**KIRKLEES METROPOLITAN COUNCIL
INVESTMENT & REGENERATION SERVICE**

**DELEGATED DECISION TO DETERMINE APPLICATIONS FOR
NON-MATERIAL AMENDMENTS**

Reference No: **2022/NM/92850/E**

Description: Non material amendment to previous permission
2022/91547 for erection of front dormer extension

FRONT ELEVATION (PROP.)
WEST

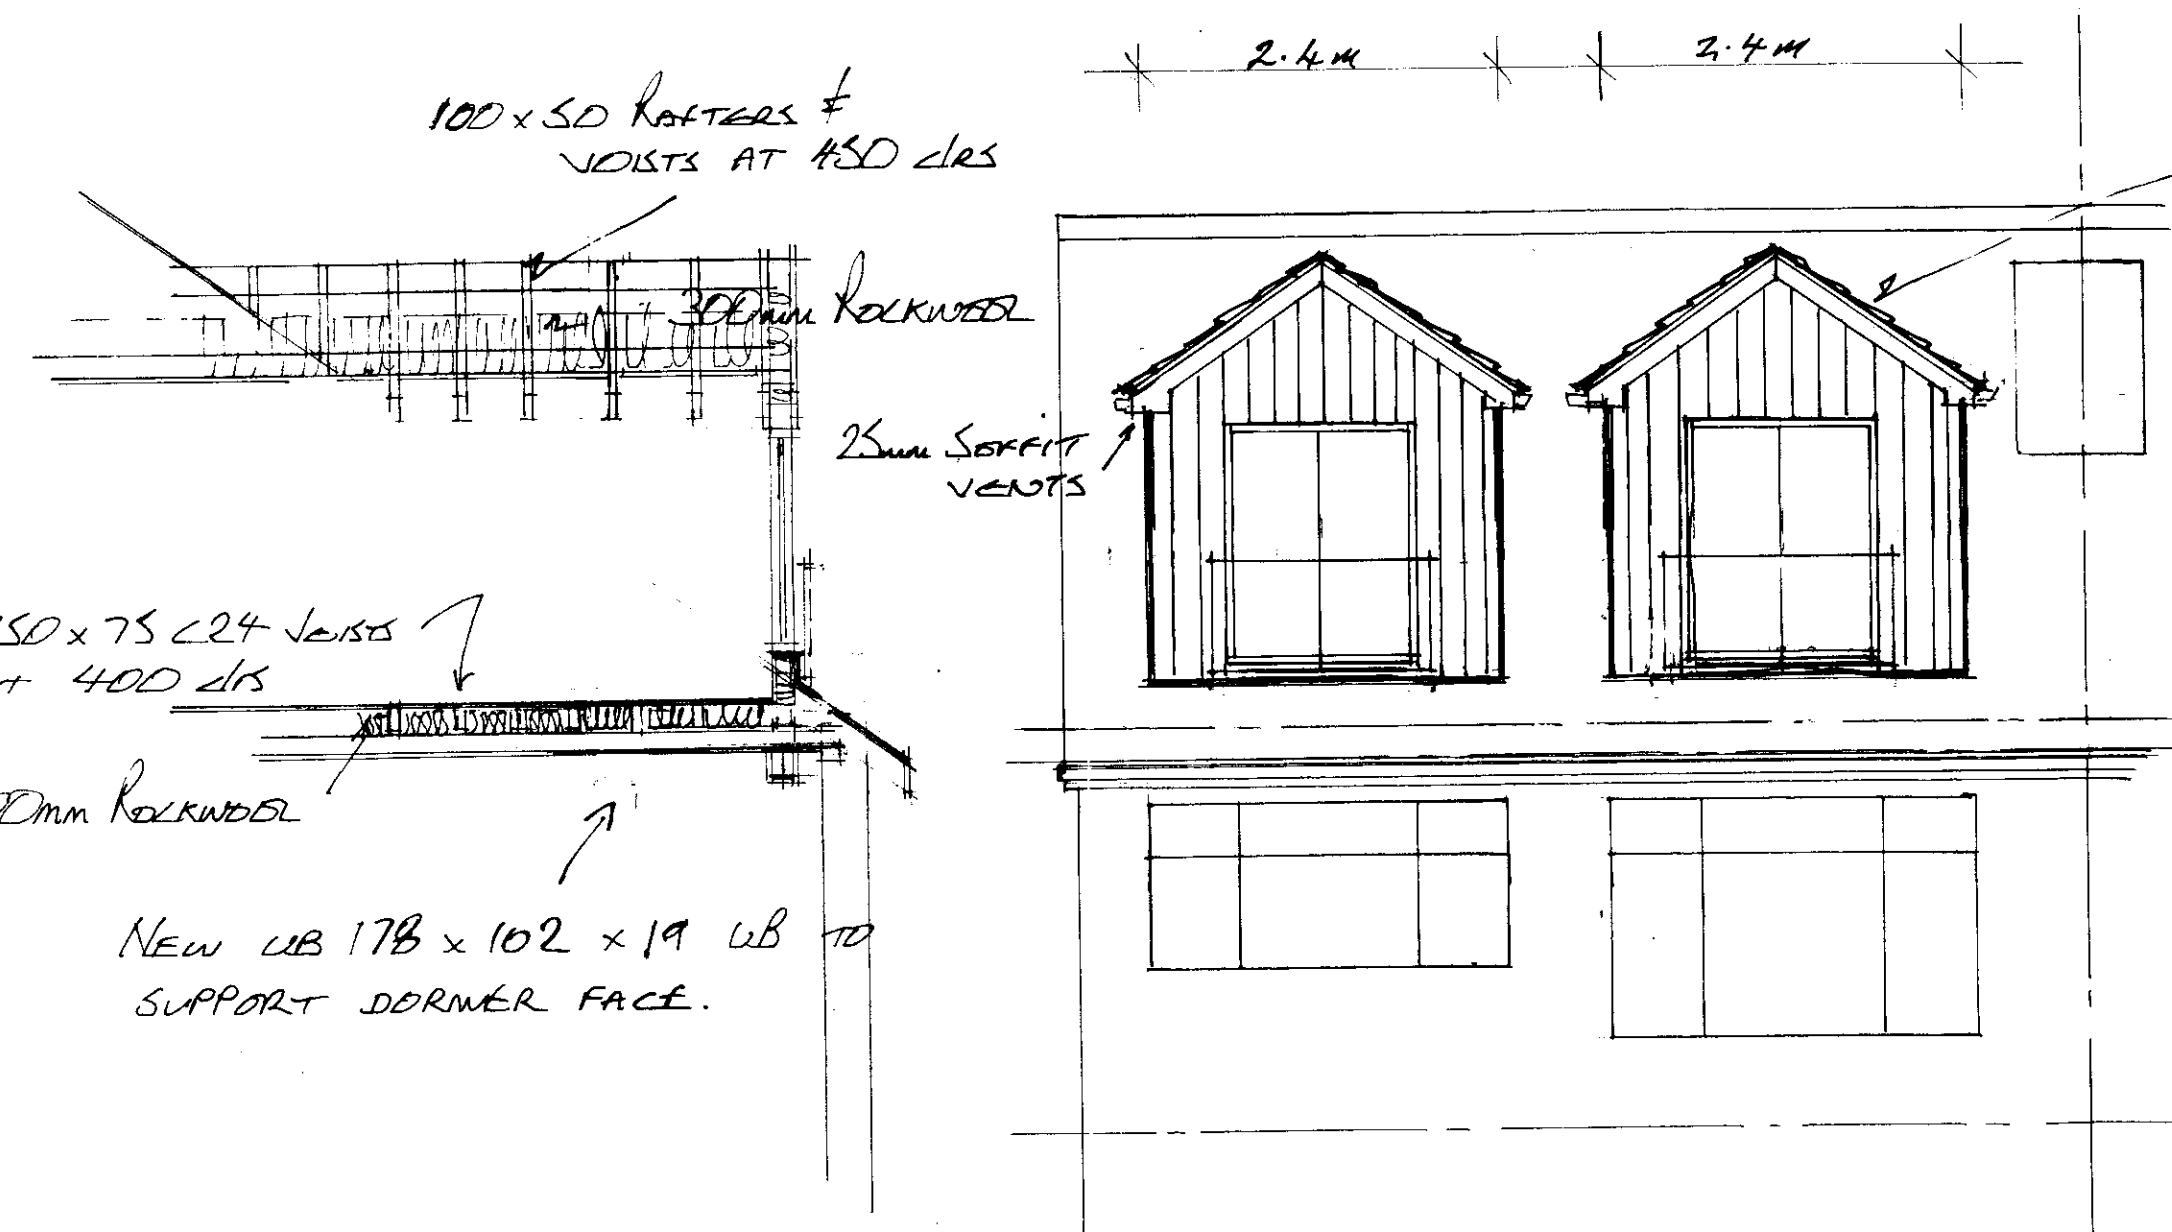
The proposed increase in projection and massing of the front extensions would not introduce any additional overshadowing, loss of light or other residential amenity effects on neighbours or occupants. The increase in projection would not be visually marked or noticeable in the context of the development as a whole when compared to the original planning permission, nor would it make the extension appear materially more prominent in the streetscene than what has already been approved. It would not be a material amendment in respect of the design of the scheme and its impact on the character of the area.

SIDE ELEVATION (PROP.)
NORTH

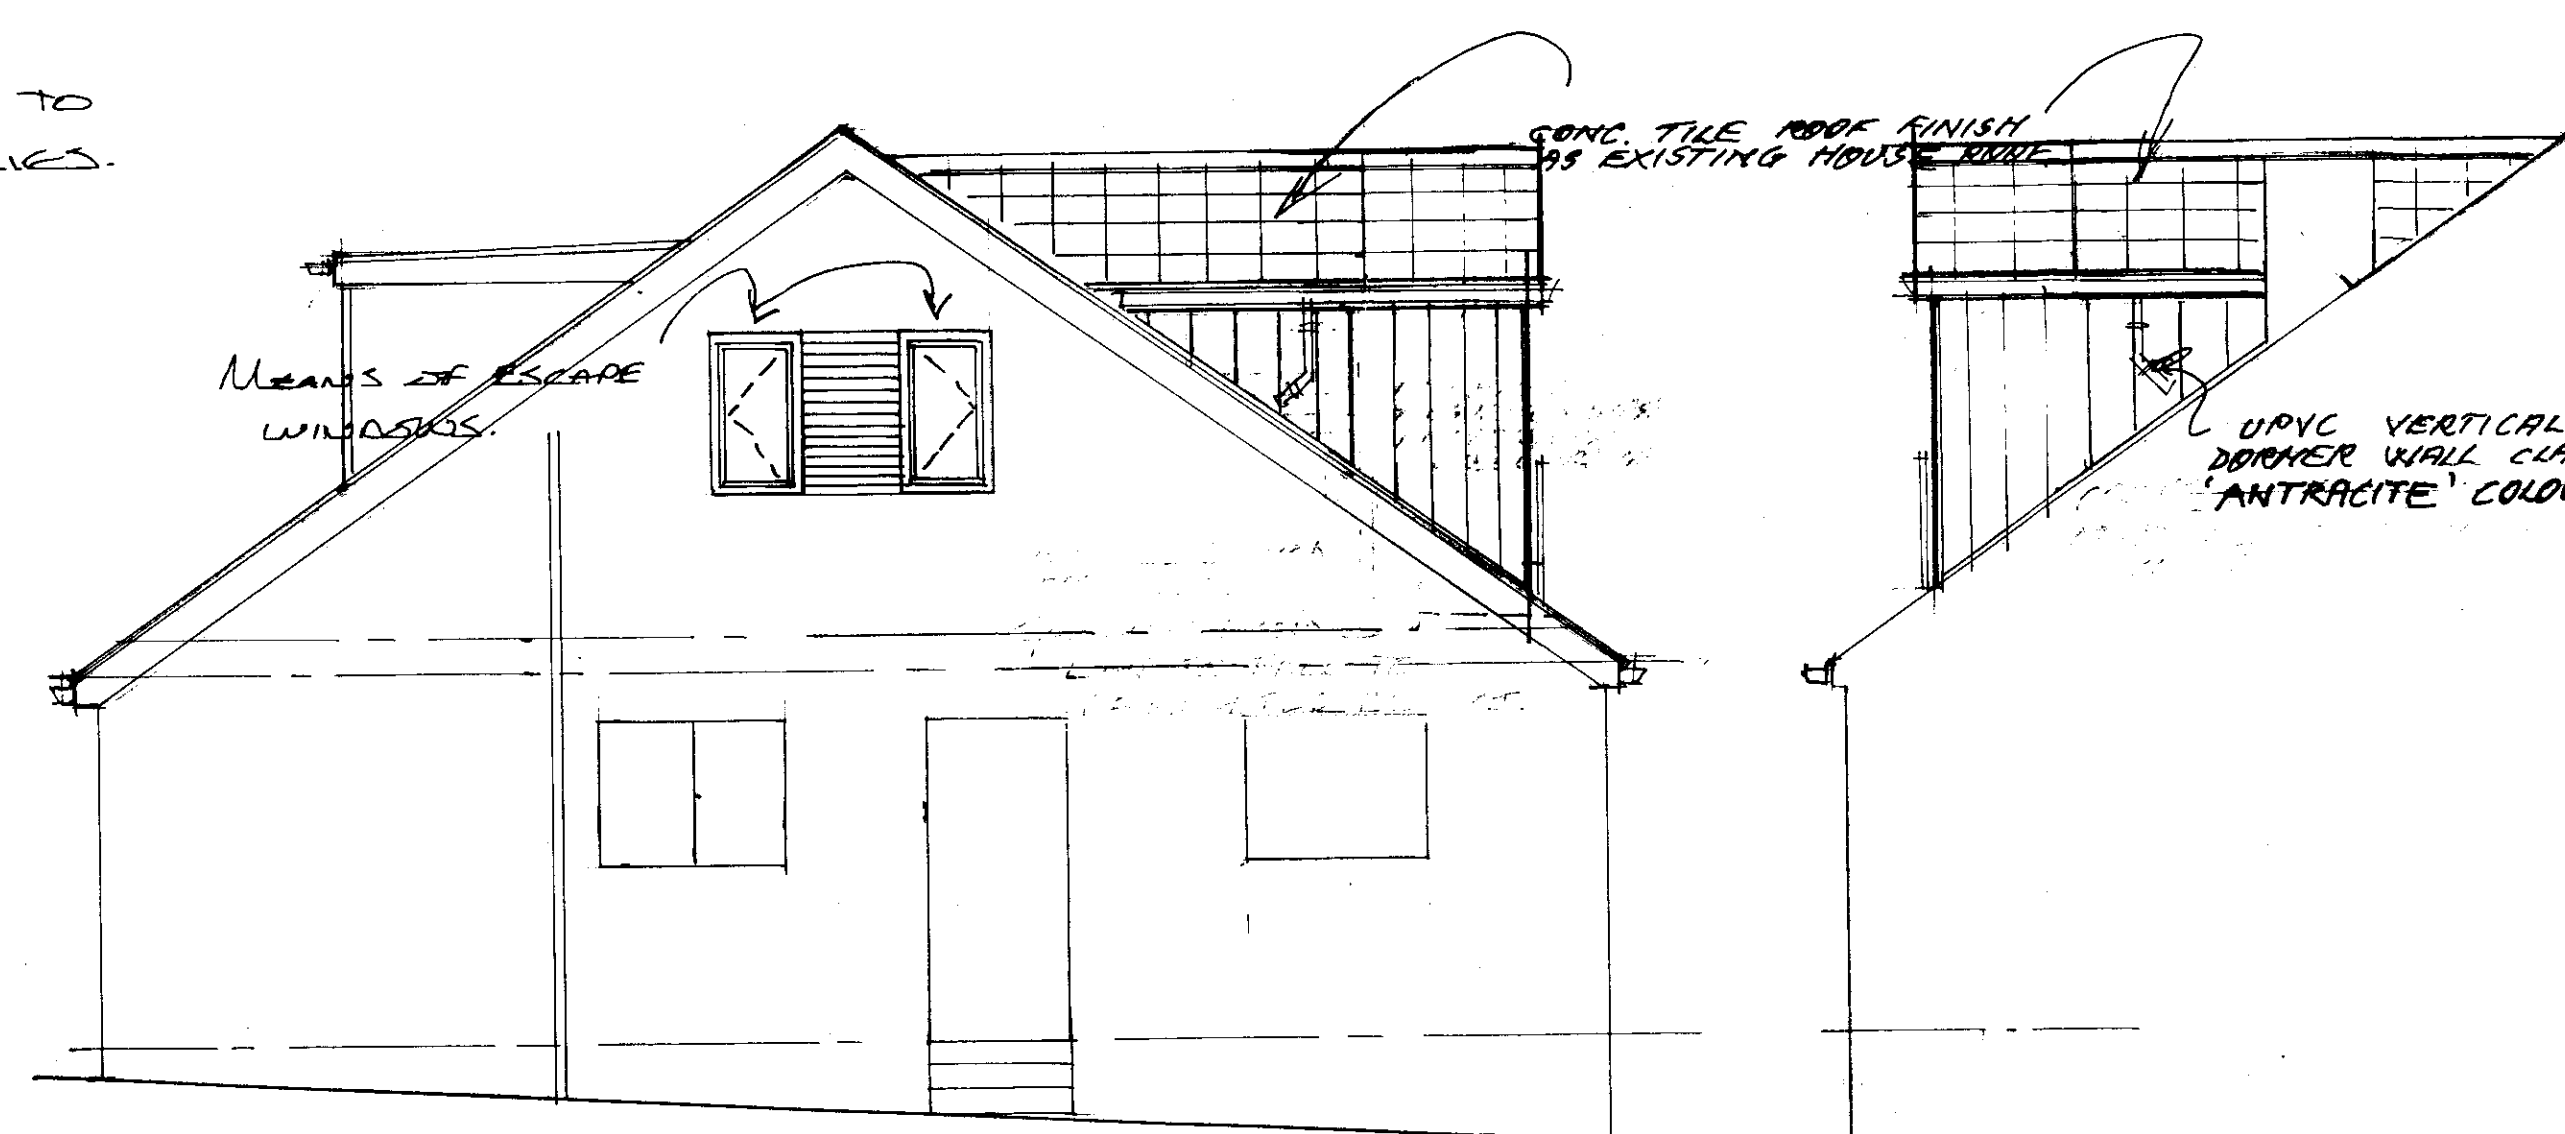
The amendment seeks to increase the projection of the front dormers by some 1.4m. This would reduce the space between the proposed dormers and the eaves from the approved approx. 1.6m gap to a proposed approx. 0.5m. The amendments have been detailed in the application form and drawing 22/68/A Rev B received by the Local Planning Authority on 25/AUG/2022.

It is considered that the overall appearance and design of the development will not be materially altered by the modest increase of the projection of these dormer windows. It would not appear any more prominent compared to the extant permission when viewed from the public highway looking at the side elevation of the building. The proposed NMA amendment would not materially increase the bulk or massing of the front dormer extension such that any new policy considerations would be engaged.

The proposed amendment seeks to increase the projection of the front dormers by some 1.4m. This would reduce the space between the proposed dormers and the eaves from the approved approx. 1.6m gap to a proposed approx. 0.5m. Following an assessment, it is concluded that the overall appearance and design of the approved development would not be altered significantly by the visual change in the roof slope. This would not add materially to the footprint of the extension not significantly impact the bulk and massing of the building. The proposed amendment would be inconsequential in terms of the scale of the approved development. Therefore, as this amendment meets the test set out for non-material amendments, the proposed increase in projection of the dormer extensions are considered acceptable as a non-material amendment to the previously approved scheme and is hereby approved.
